**CITY OF ALBUQUERQUE  
PLANNING DEPARTMENT  
February 3, 2016  
DRB Comments**

**PROJECT # 1006201**

**RE: Tract D, Mesa del Sol Innovation Park II**

**PLAT OF
TRACTS D-1 THRU D-7
MESA DEL SOL
INNOVATION PARK II**

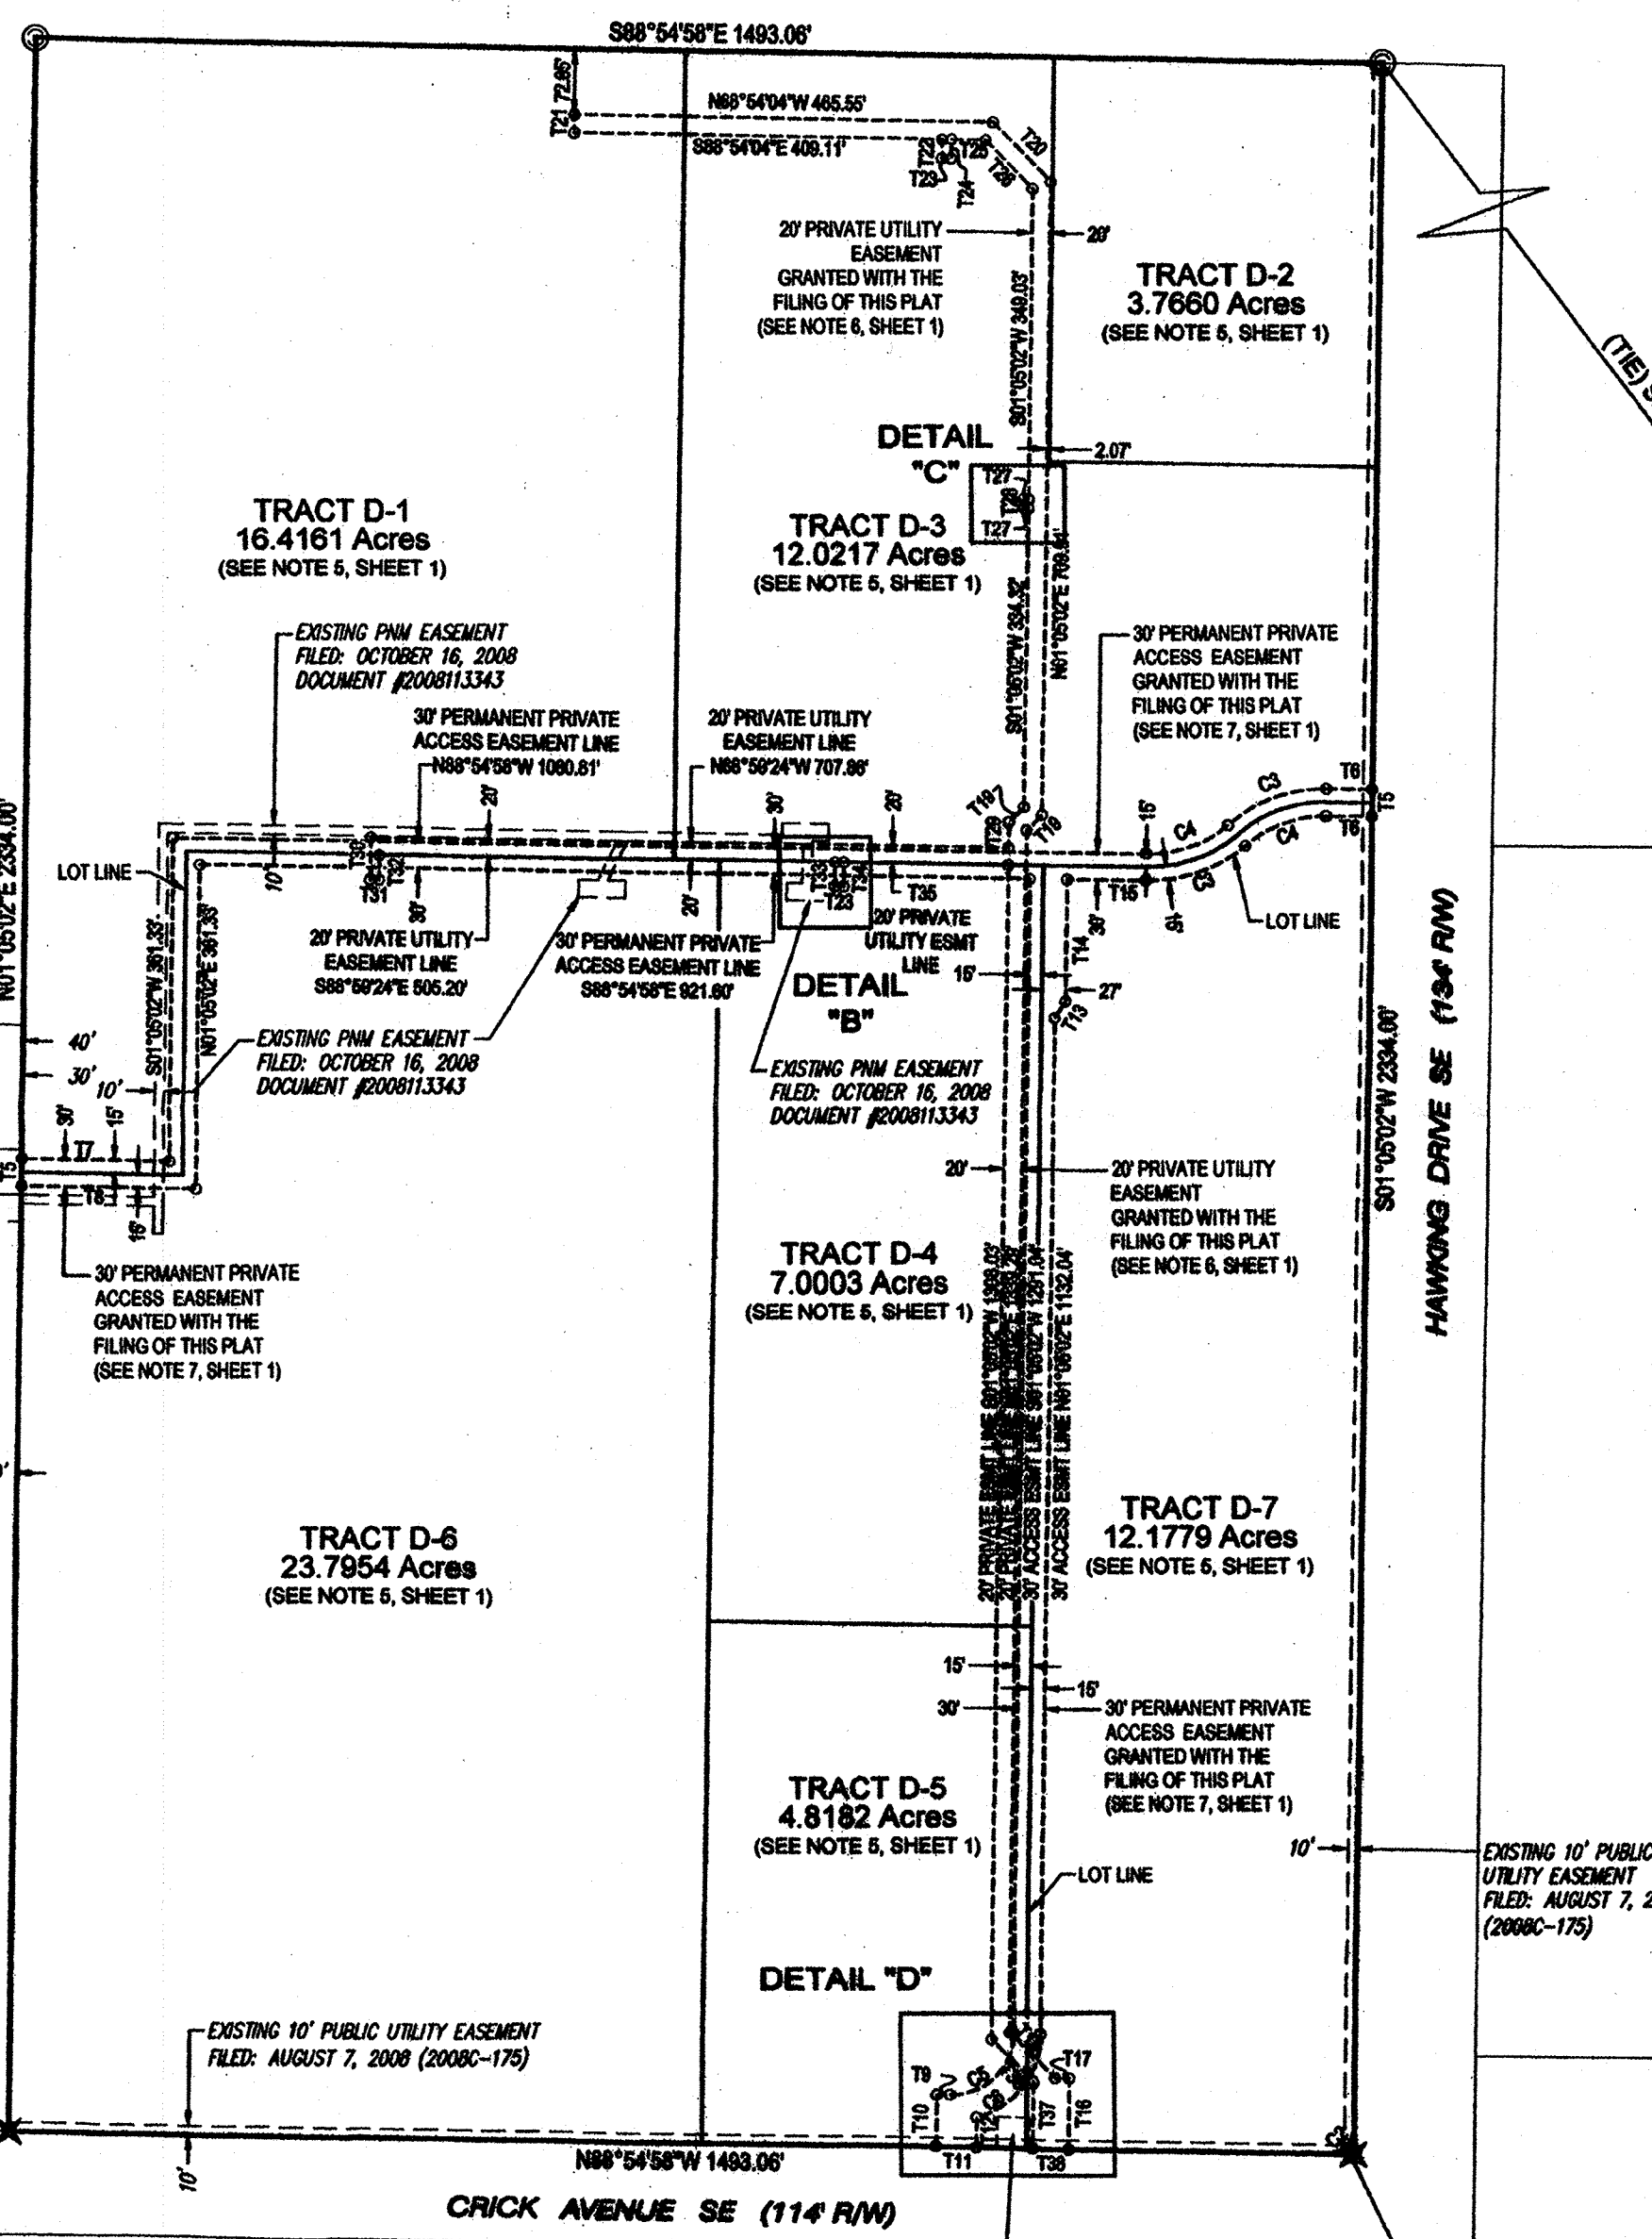
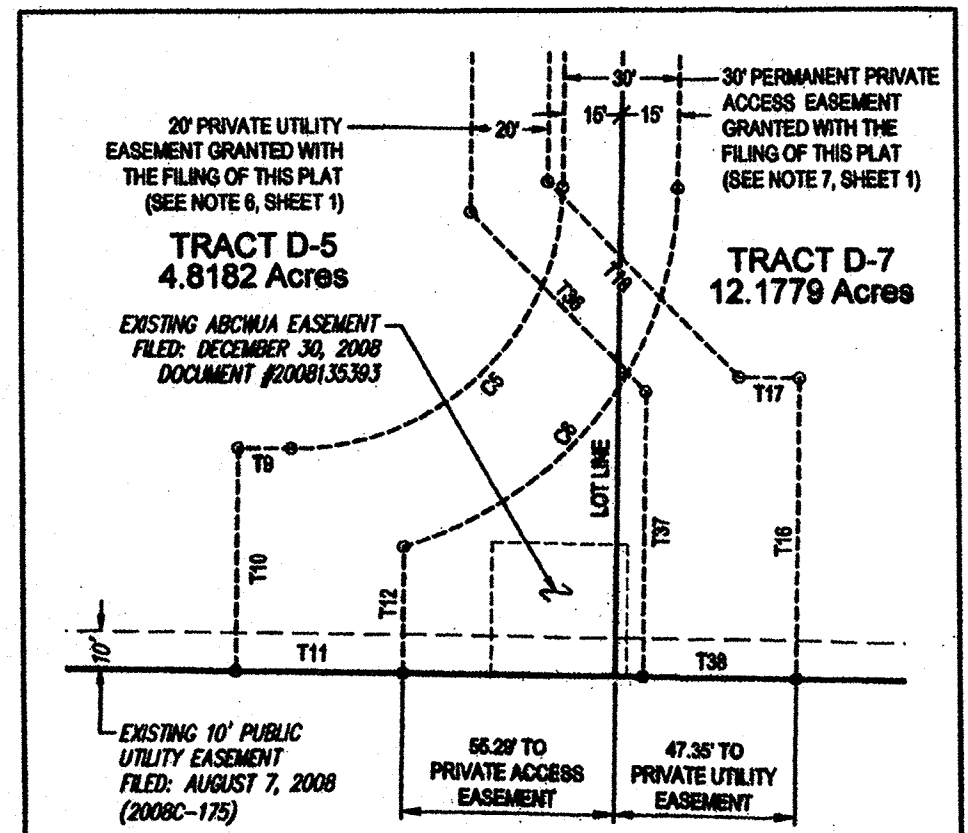
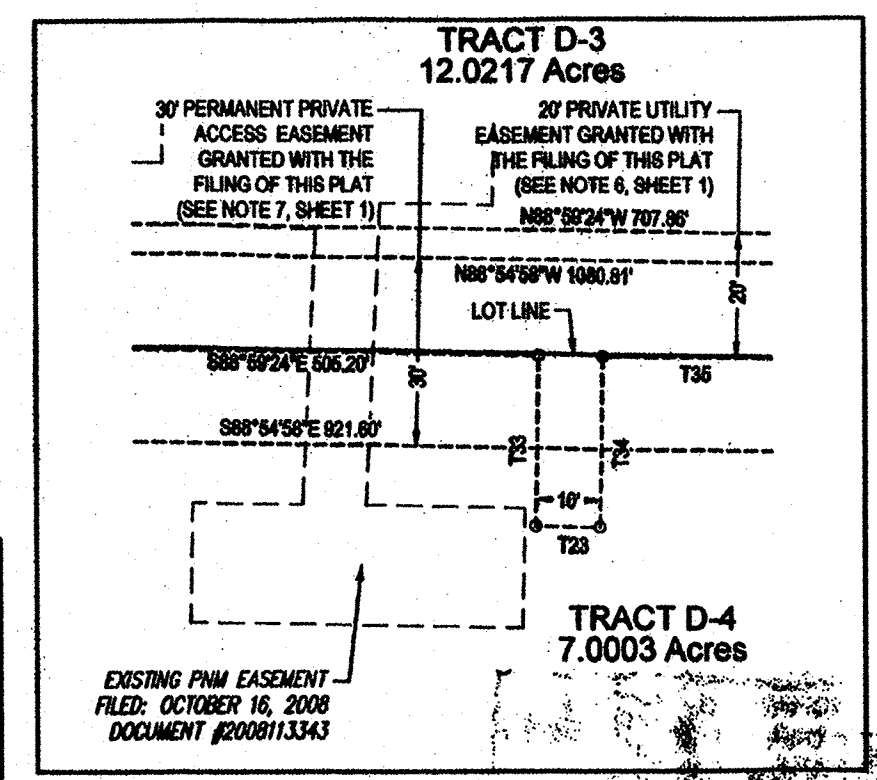
Proposed Lots 3 and 4 must demonstrate compliance with On-site parking requirements, which means required parking must be on the same lot as a building.

Infrastructure will need to be extended to cover the frontage of proposed Lot 2; refer to comments from other agencies regarding acceptance of private driveways and utilities for shared/ public easements.
